Whalley Parish Council

PLANNING APPLICATIONS

3/2012/0270 Proposal: Two storey extension to side of property

Location: 18 King St Whalley BB7 9SL

PROPOSED GROUND FLOOR PLAN / SITE PLAN
SCALE 1:50

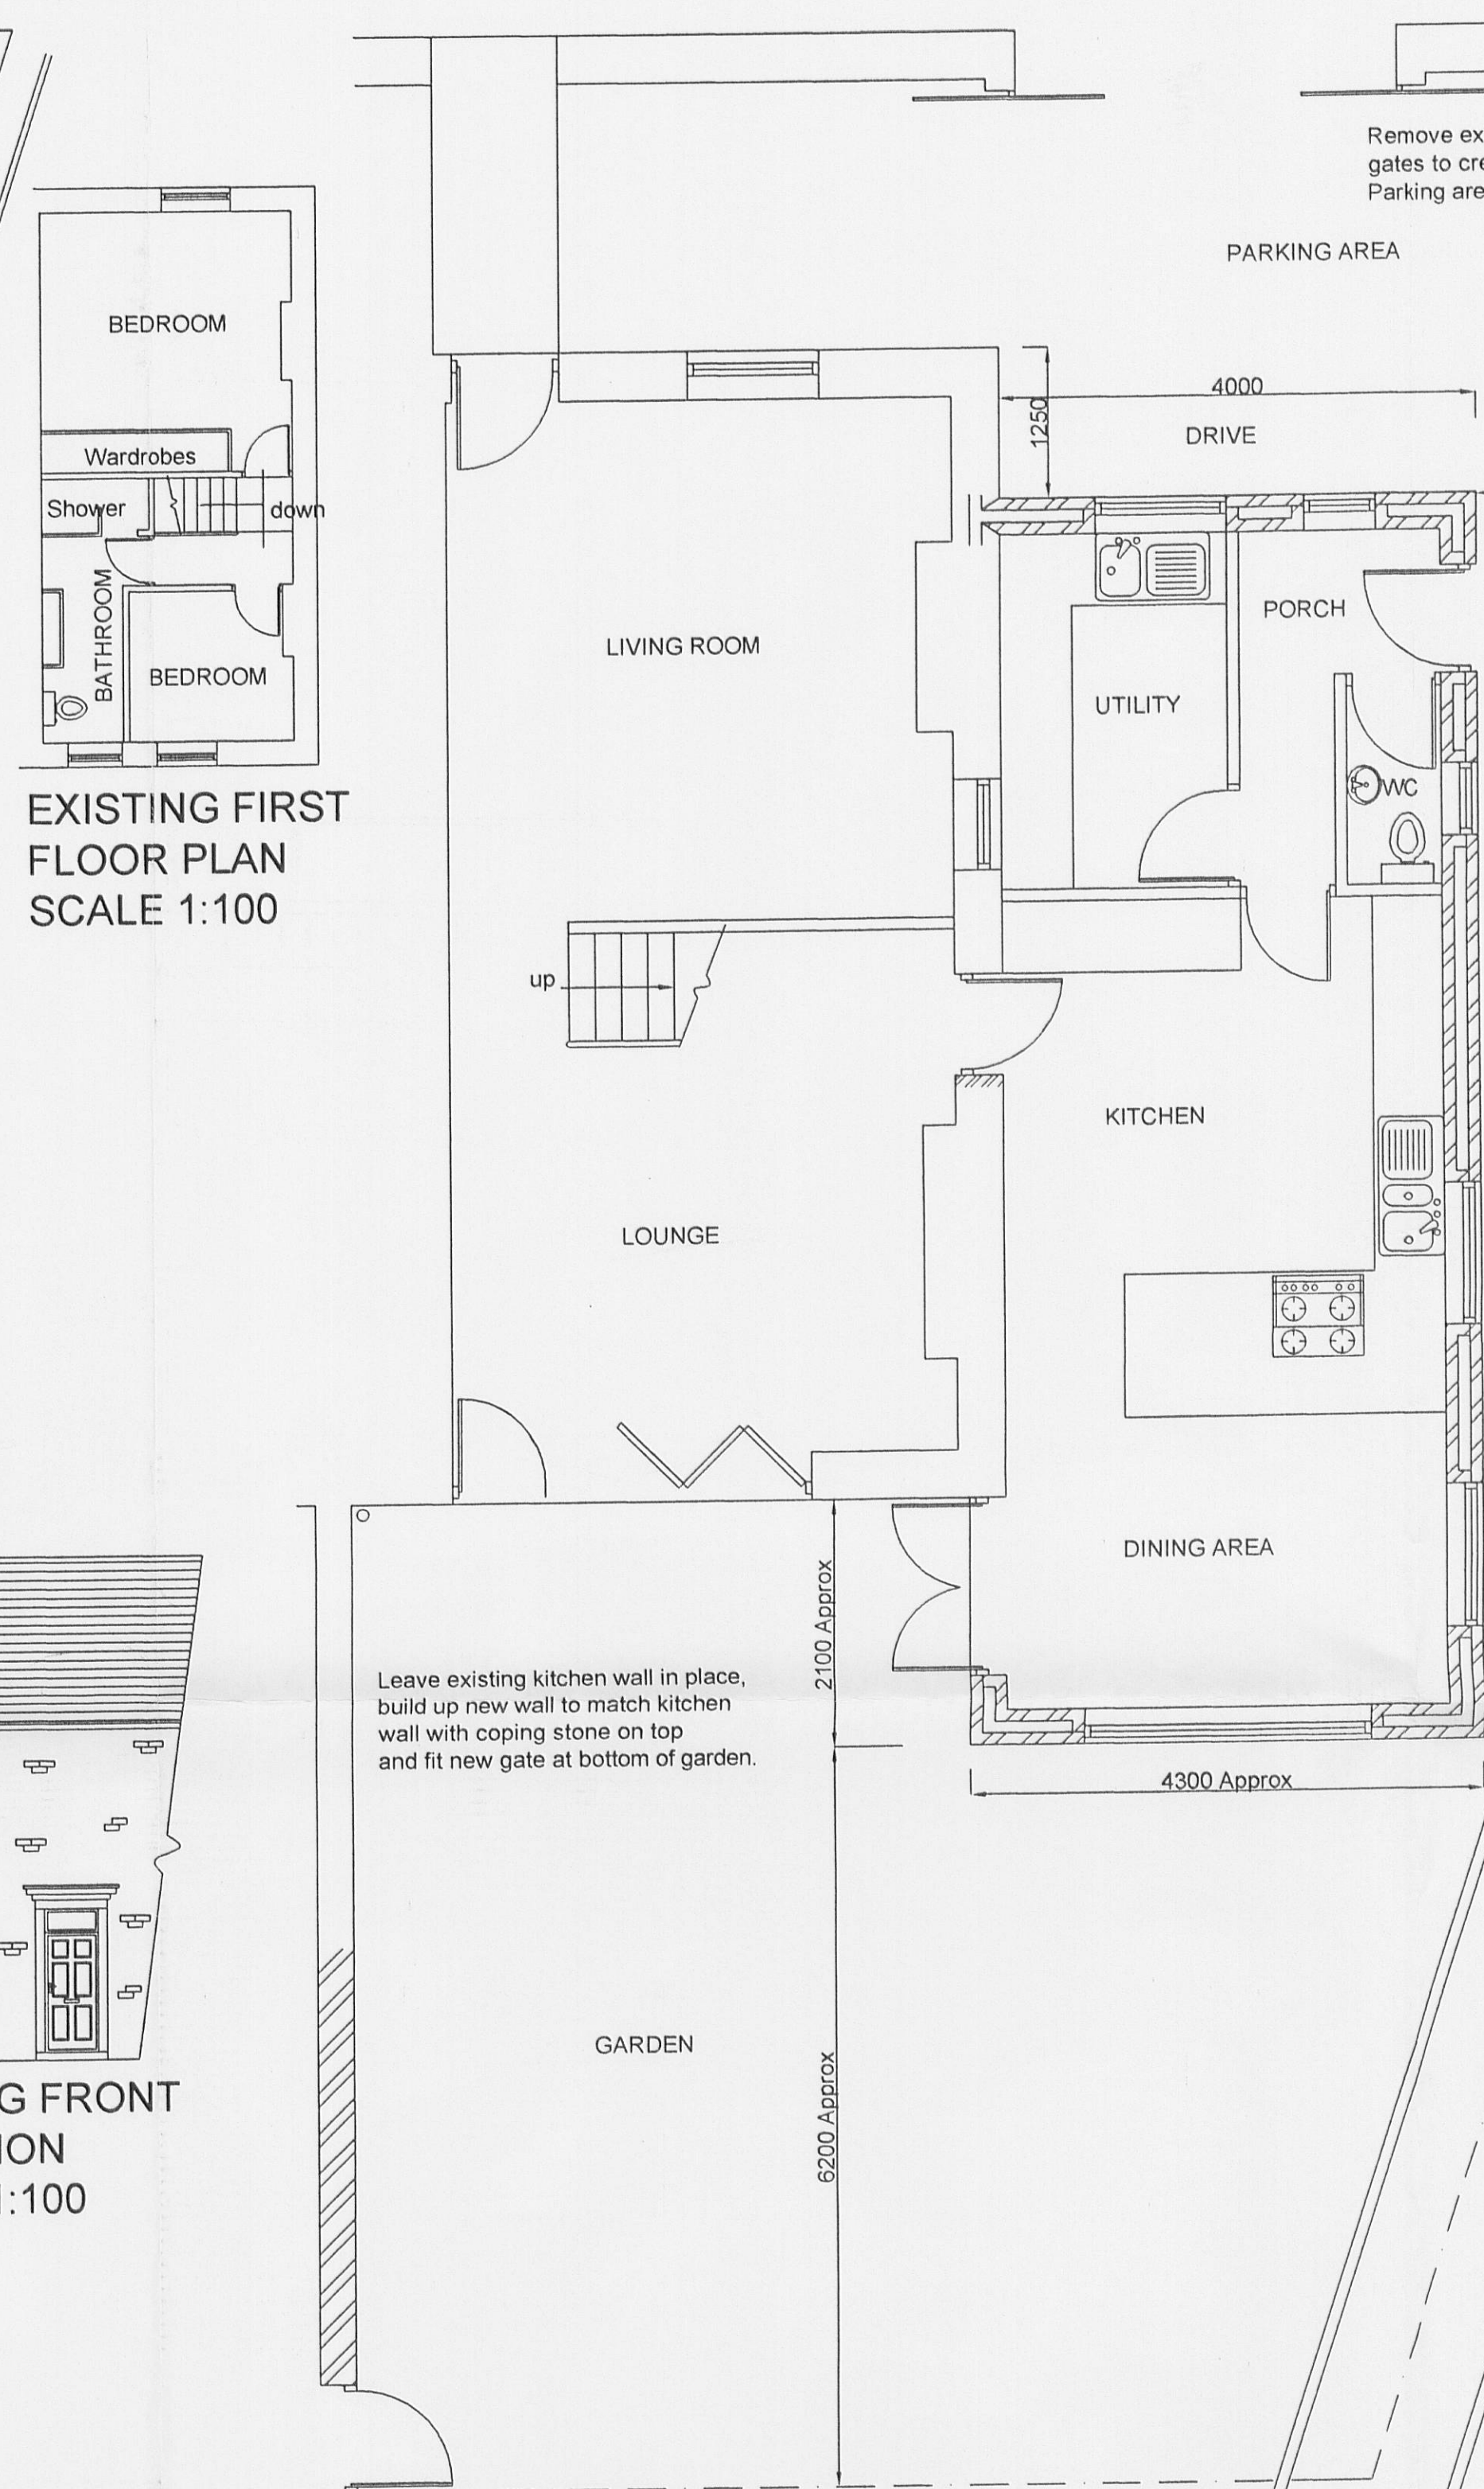
The parish council seek assurances that the Environmental Agency are satisfied that there is no transgression onto the culvert and no damage is caused to the immediate area. Furthermore concern is expressed regarding the proposed removal of on - site parking which in turn will increase the pressure of parked cars on King St with the attendant congestion problems.
